VENETUCCI FARMS

A PORTION OF THE SW 1/4 OF THE SW 1/4 AND THE SE 1/4 OF SECTION 11 AND A PORTION OF THE NW 1/4 OF SECTION 14, EL PASO COUNTY, COLORADO SPECIAL USE PERMIT - BUSINESS EVENT CENTER

SPECIAL USE PERMIT - BUSINESS EVENT CENTER

LANDSCAPE PLAN
BUSINESS EVENT CENTER

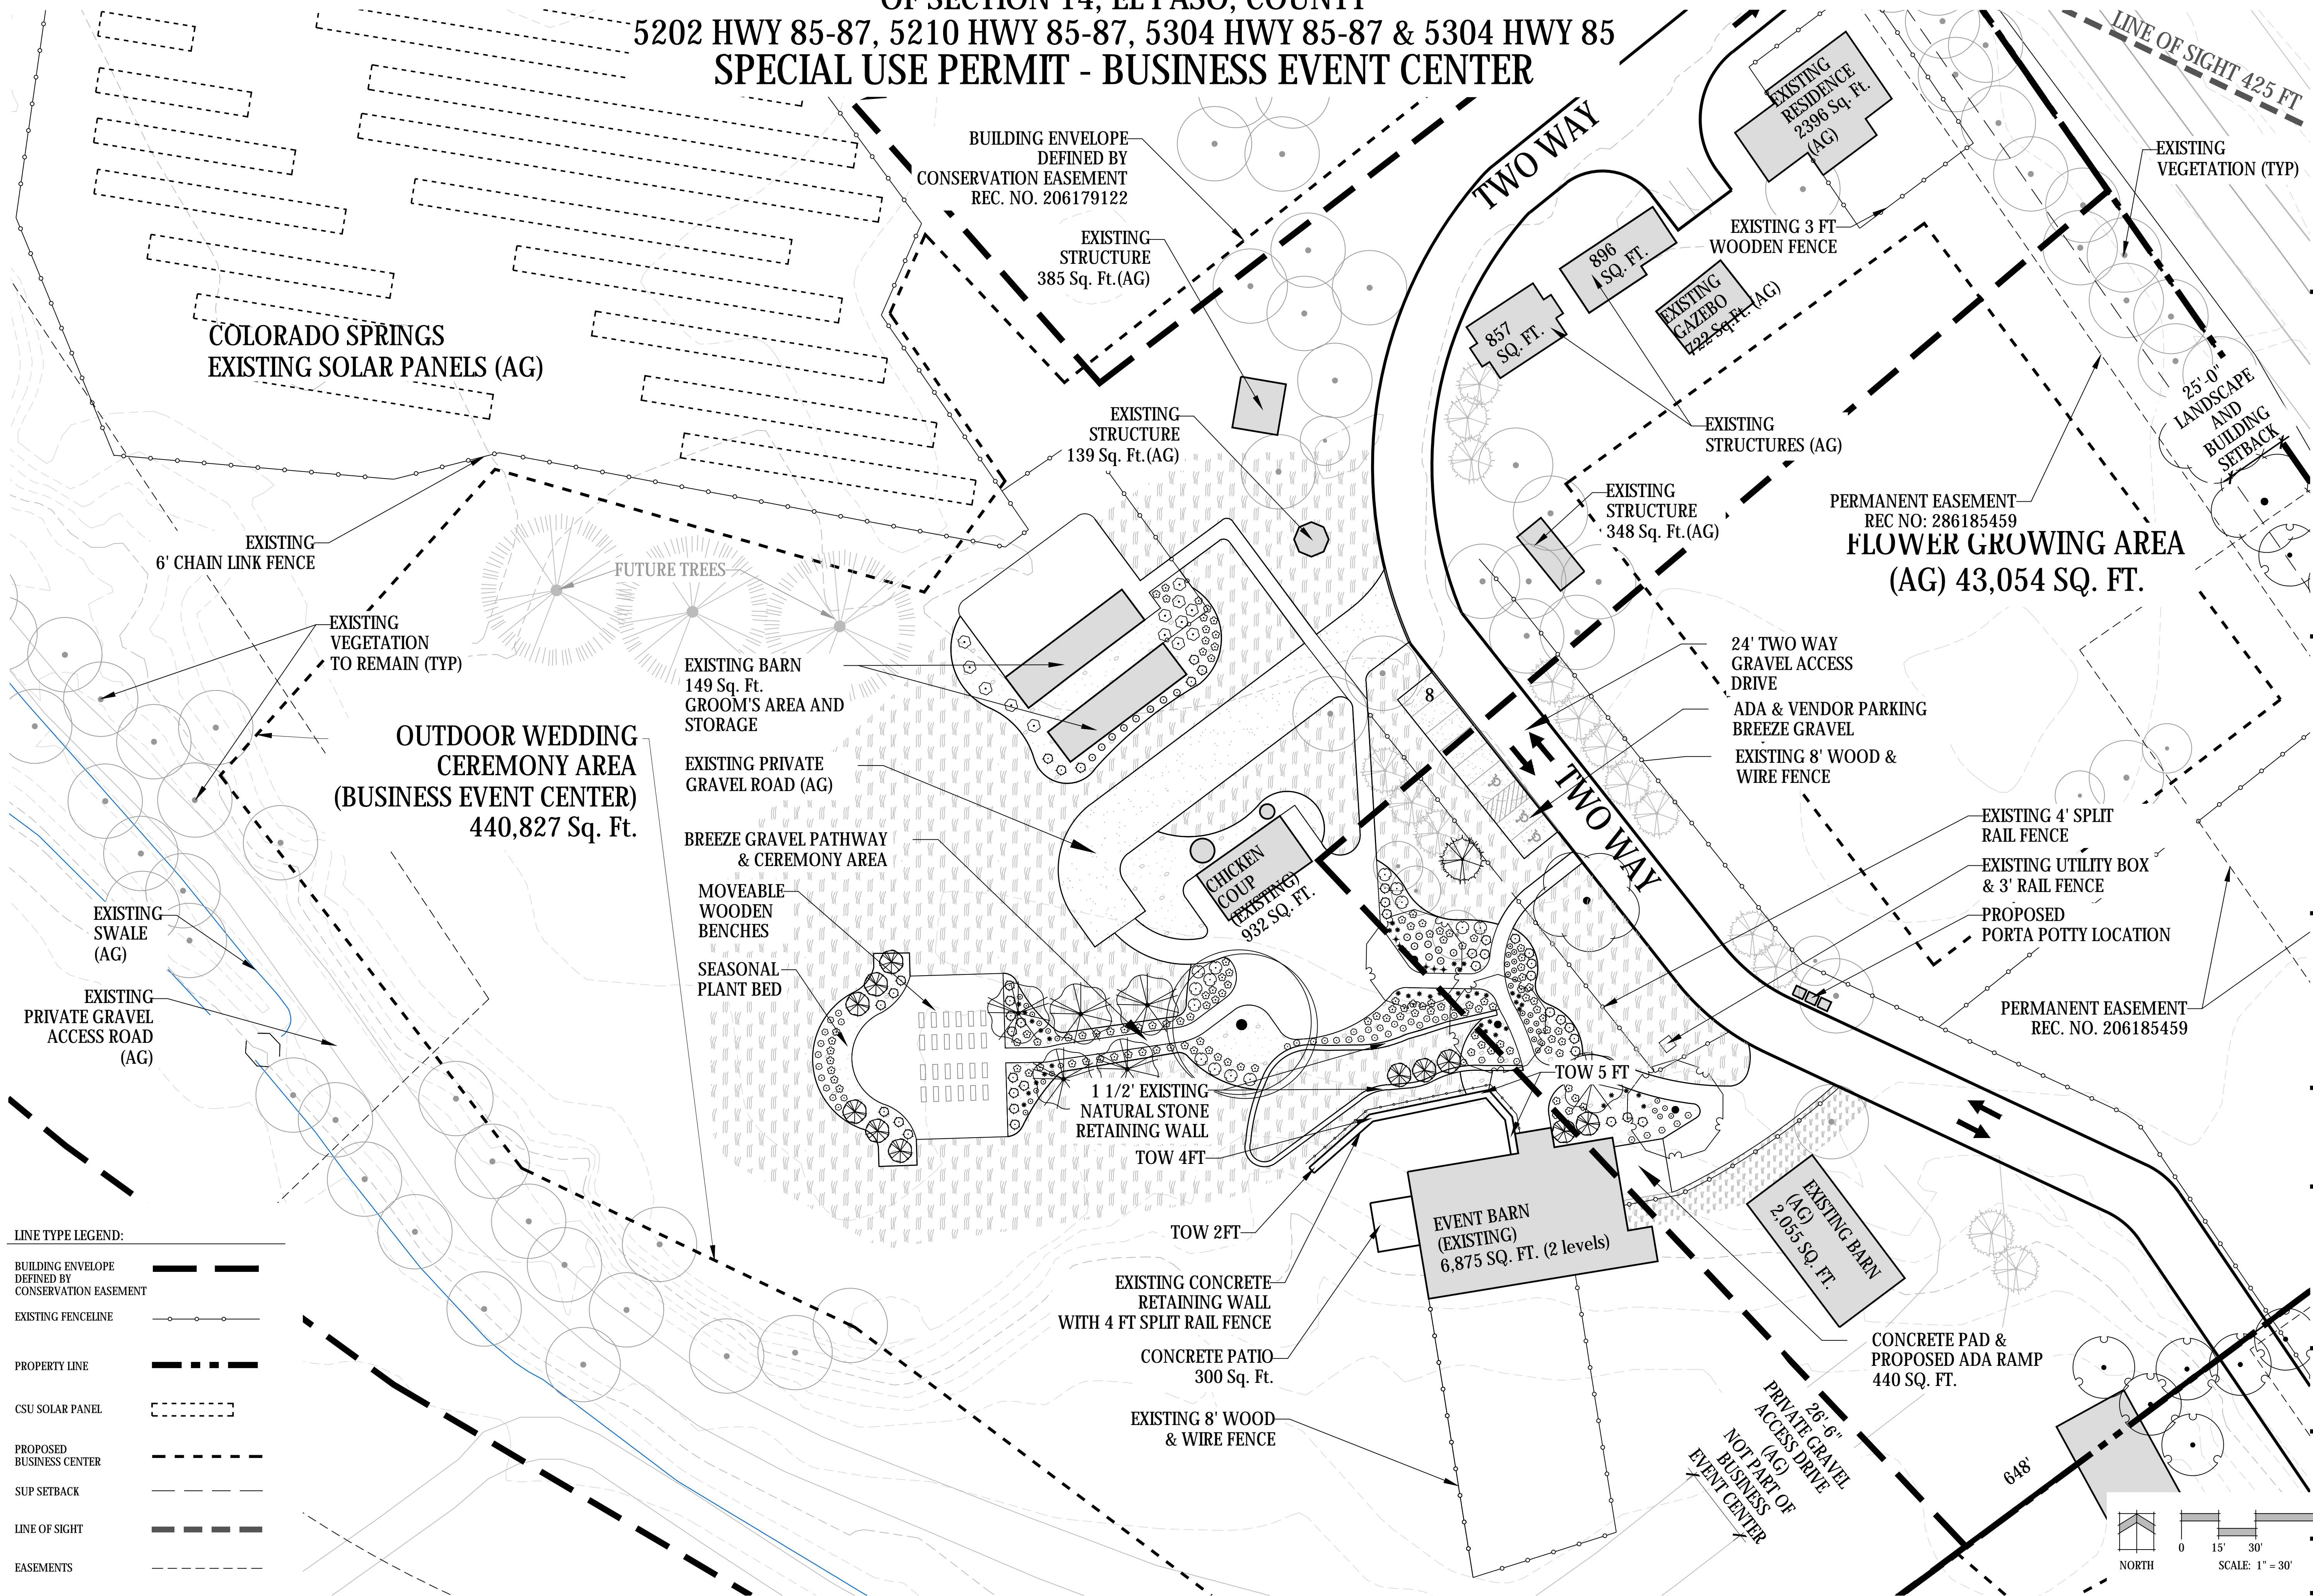
Show required parking lot landscaping
PARKING LOT LANDSCAPING HAS BEEN ADDED
